2.17.36	NE29a Protected Landscapes	<p>Comment: Natural England advises that the ES does not include a full justification as to why the project cannot avoid the Lincolnshire Wolds National Landscape.</p> <p>Recommendation</p> <ul style="list-style-type: none"> • A full justification behind the need to directly impact the National Landscape should be provided, inclusive of why route Option B1 is the only valid alternative route that directly avoids the National Landscape, and why Option B2A is the preferred route given that this option cuts through the National Landscape directly—with open trenching—and abuts it for around 3km along the A18 boundary (AS-020). 	<p>Many potential constraints were considered when developing the route of the Proposed Development, however there were six key considerations, which were:</p> <ul style="list-style-type: none"> • The safety of local communities • Built up areas or sensitive buildings such as schools • Areas protected for their habitats and species • The Lincolnshire Wolds Area of Outstanding Natural Beauty (now the Lincolnshire Wolds National Landscape (LWNL)) • Areas that are vulnerable to flooding, and • Historic monuments <p>Of these, route

4.13 Laydown, Welfare and Parking Area

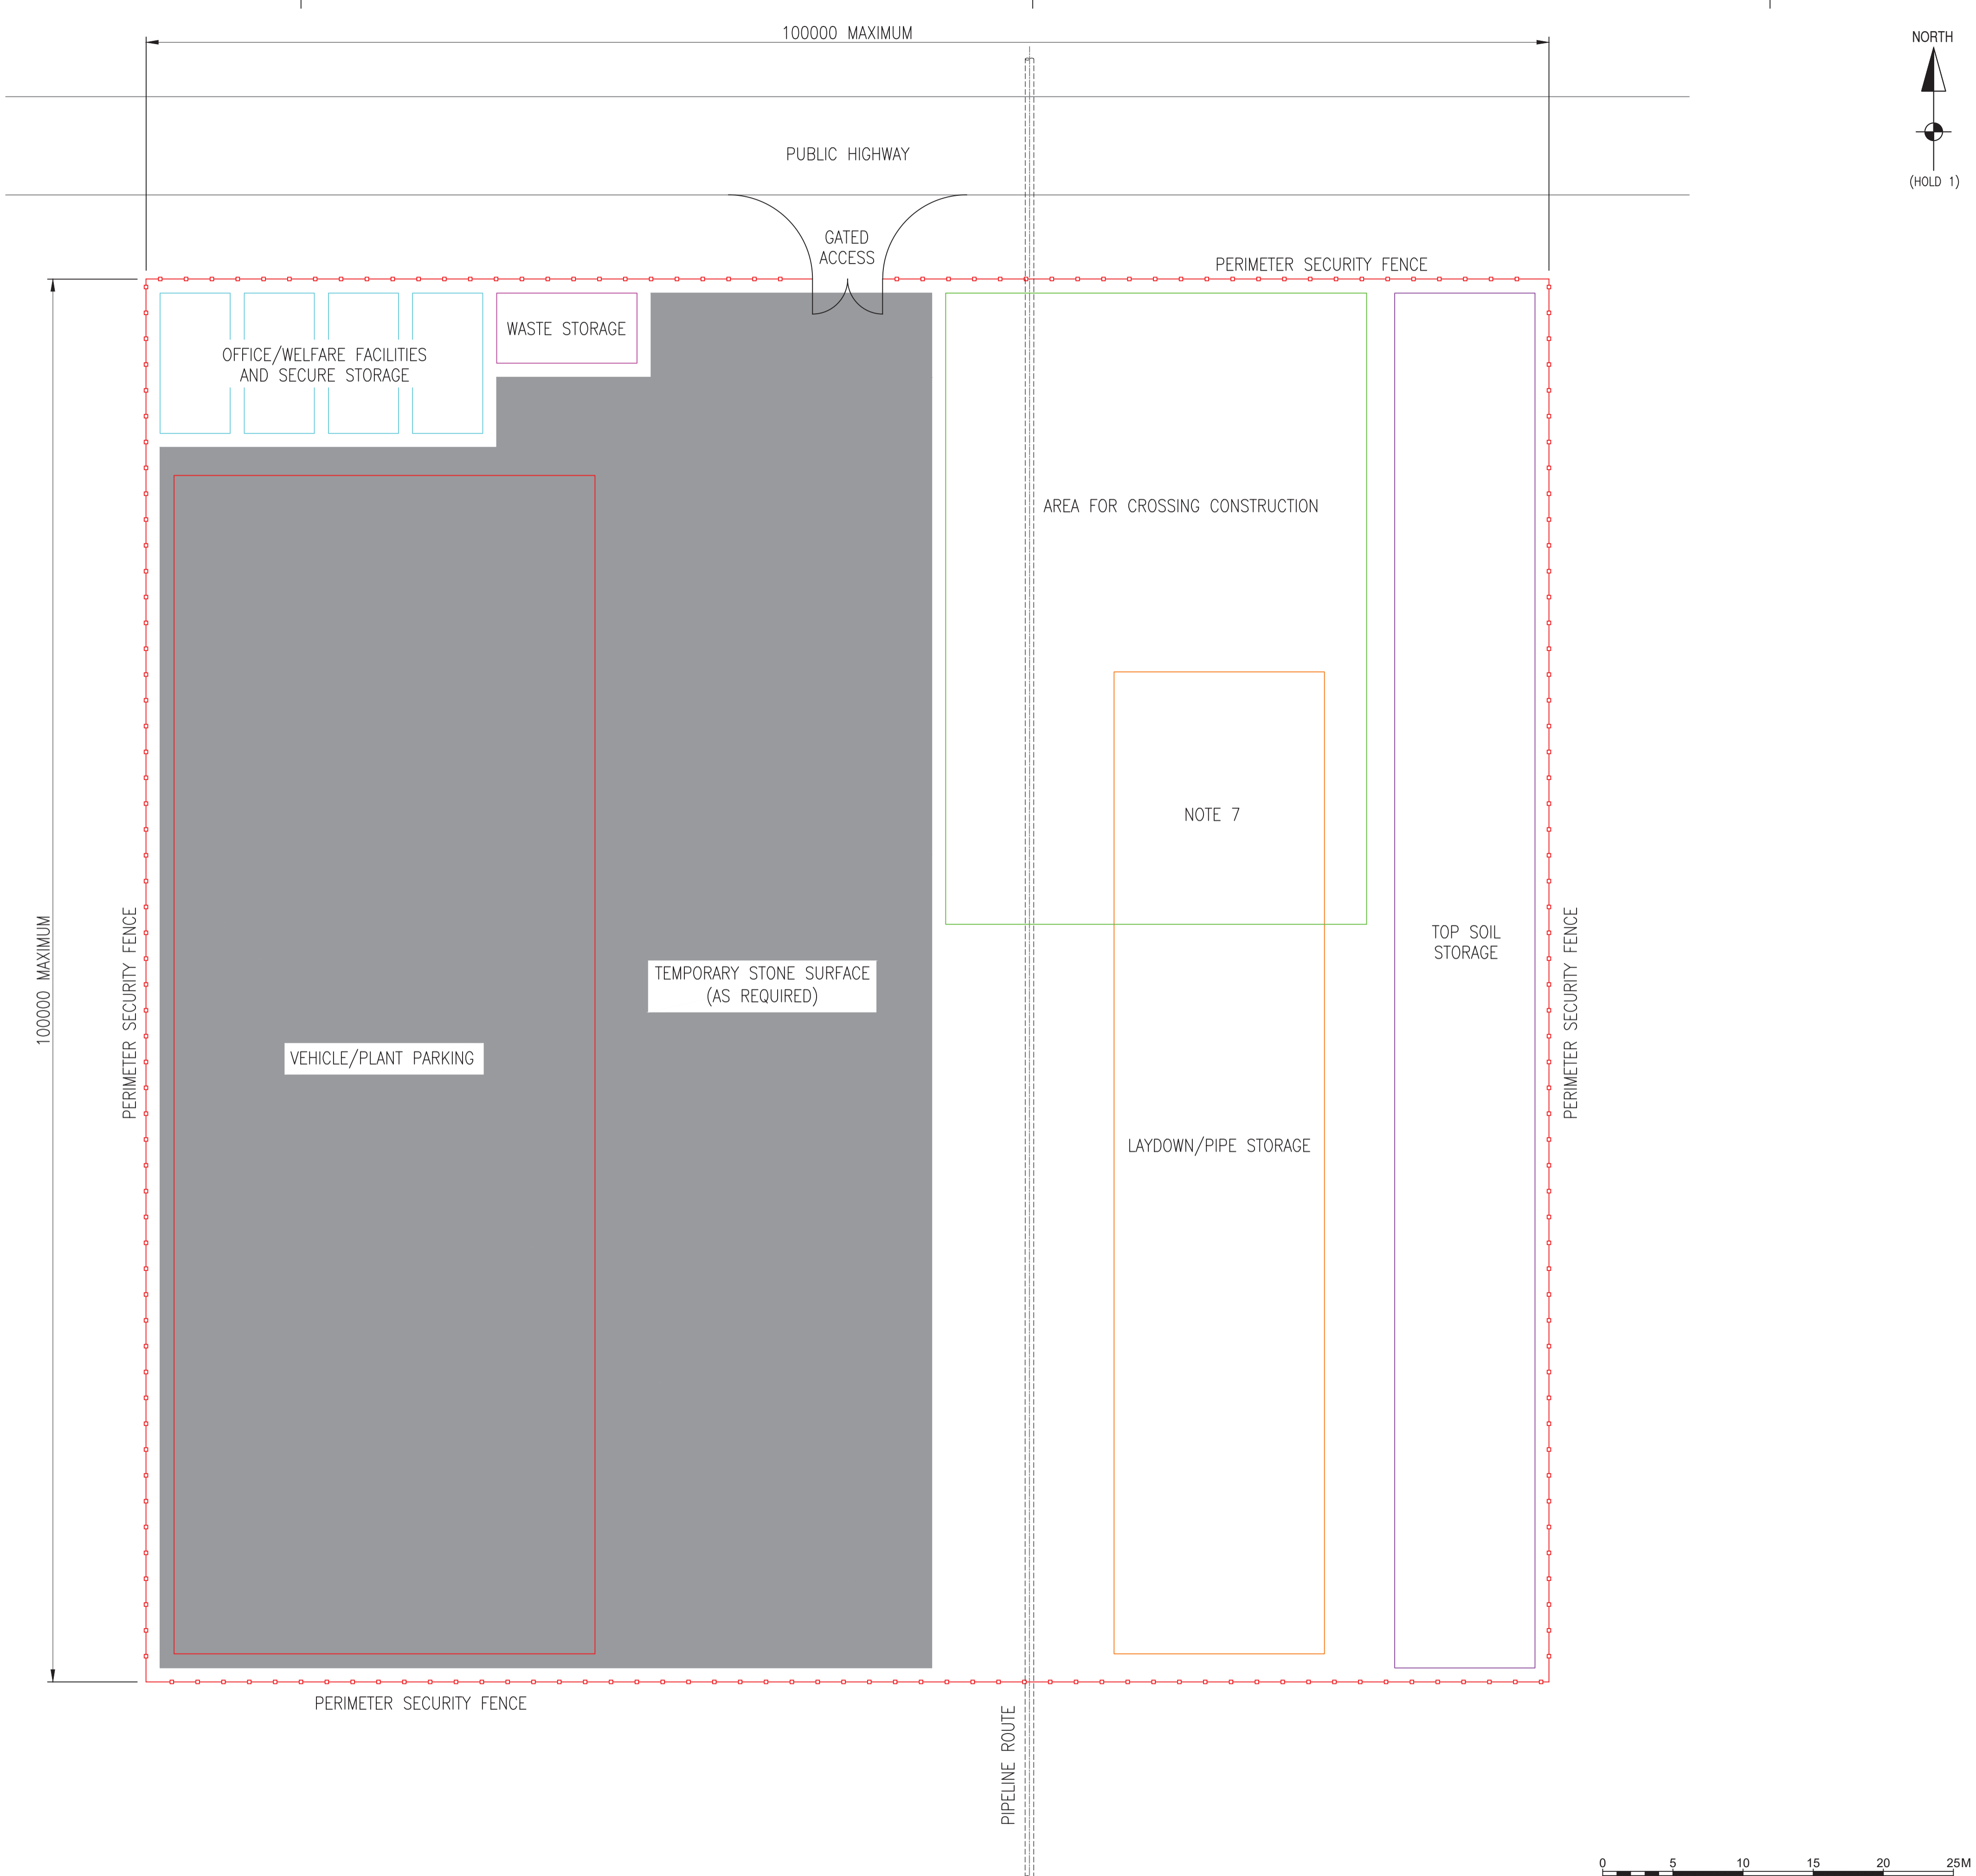
2.17.41	NE29f Protected Landscapes	<p>Comment Natural England advise that all visible surface infrastructure is considered within the landscape and visual assessment, inclusive of the temporary access and laydown areas, one of which includes HGV parking and hard infrastructure within the Lincolnshire Wolds National Landscape boundary near Irby upon Humber (Chapter 3, Figure 3-30 1 of 3, APP-045).</p> <p>Recommendation</p>	<p>All visible infrastructure associated with the Proposed Development including the impact of temporary access and laydown areas have been assessed within ES Chapter 7 Landscape and Visual [APP-049].</p>
		<ul style="list-style-type: none"> • Provide justification that all visible surface infrastructure is considered within the landscape and visual assessment. 	<p>The assessment presented in ES Chapter 7 Landscape and Visual [APP-049] includes all visible infrastructure associated with the Proposed Development. Paragraph 7.8.2 to 7.8.6 notes the various elements potentially impacting landscape and visual receptors by category and stage (construction/operation). In the assessment each section has a summary of effects from the combined elements and if applicable those in other sections, noting that the pipeline is the main element which potentially gives rise to inter-section effects and there is little or no</p>

<p>intervisibility from other elements such as BVS due to distance and intervening vegetation.</p> <ul style="list-style-type: none"> • The assessment presented in ES Chapter 7 Landscape and Visual [APP-049]. includes the impact of temporary access and laydown areas. Their presence is highlighted at Para 7.8.2 and then throughout the Visual Assessment as part of the construction activity described for individual viewpoints.
		<ul style="list-style-type: none"> • Ensure the landscape and visual assessment considers the impact of temporary access and laydown areas.
